From: Michael Eastham
Sent: 17 April 2019 16:33
To: Planning.Responses
Subject: FW: BE/1/19/DOC - Land at Salt Box, west of Shripney Road

From: Fiona Fitzgerald
Sent: 17 April 2019 16:30
To: Michael Eastham
Subject: RE: BE/1/19/DOC - Land at Salt Box, west of Shripney Road

Are you happy for me to discharge **condition 21** regarding external lighting for Salt Box?

2 Appendix: Indicative External Lighting Levels

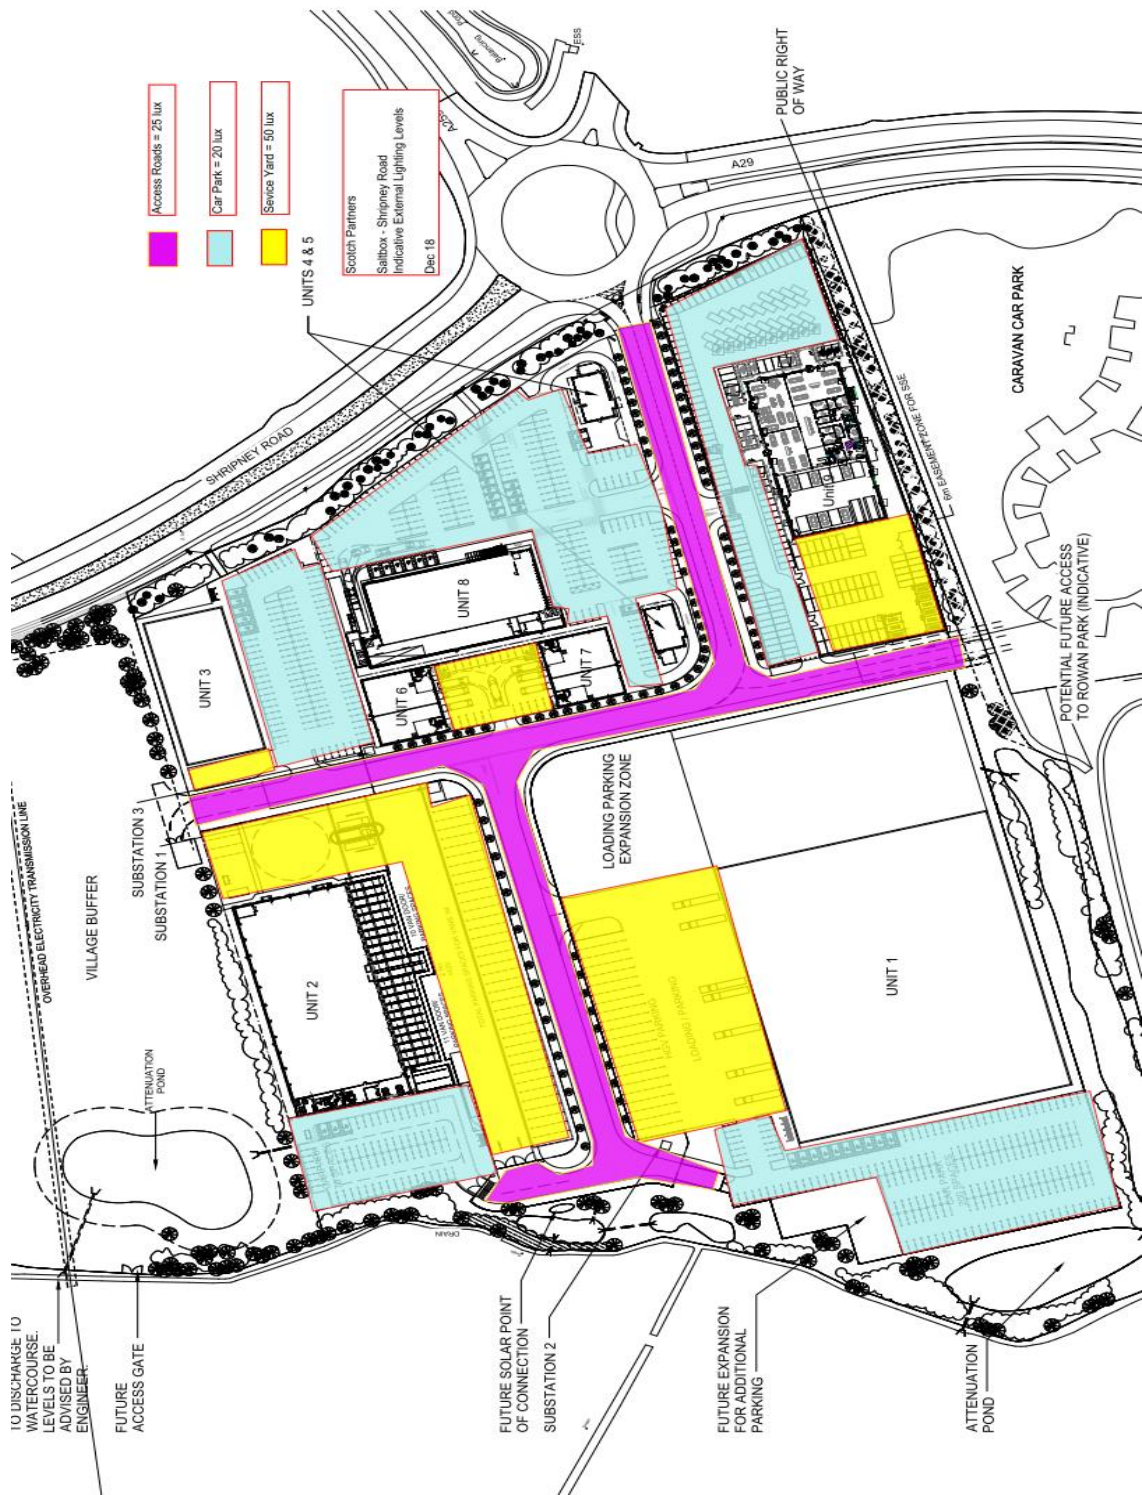
Please could you amend the External Lighting & CCTV Planning Statement by inserting "Revision 1" and updating the date of the document to "15/04/2019" and remove all references to "E3".

This is because the condition itself details **Zone E2** (Rural, low district brightness) from the ILP Guidance Notes for the Reduction of Obtrusive Light, but the report 'External Lighting and CCTV Planning Statement' Revision 0, dated 10/12/18 by Scotch Partners LLP, paragraph 1.3 (Basis of Design) refers to **Zone E3** (Suburban, medium district brightness).

I have amended the statement to E2. I have also attached the Holophane BREEAM spreadsheet which confirms the scheme is compliant with E2 requirements and the ULR 0.06% which is lower than 2.5% ILP Guidance.
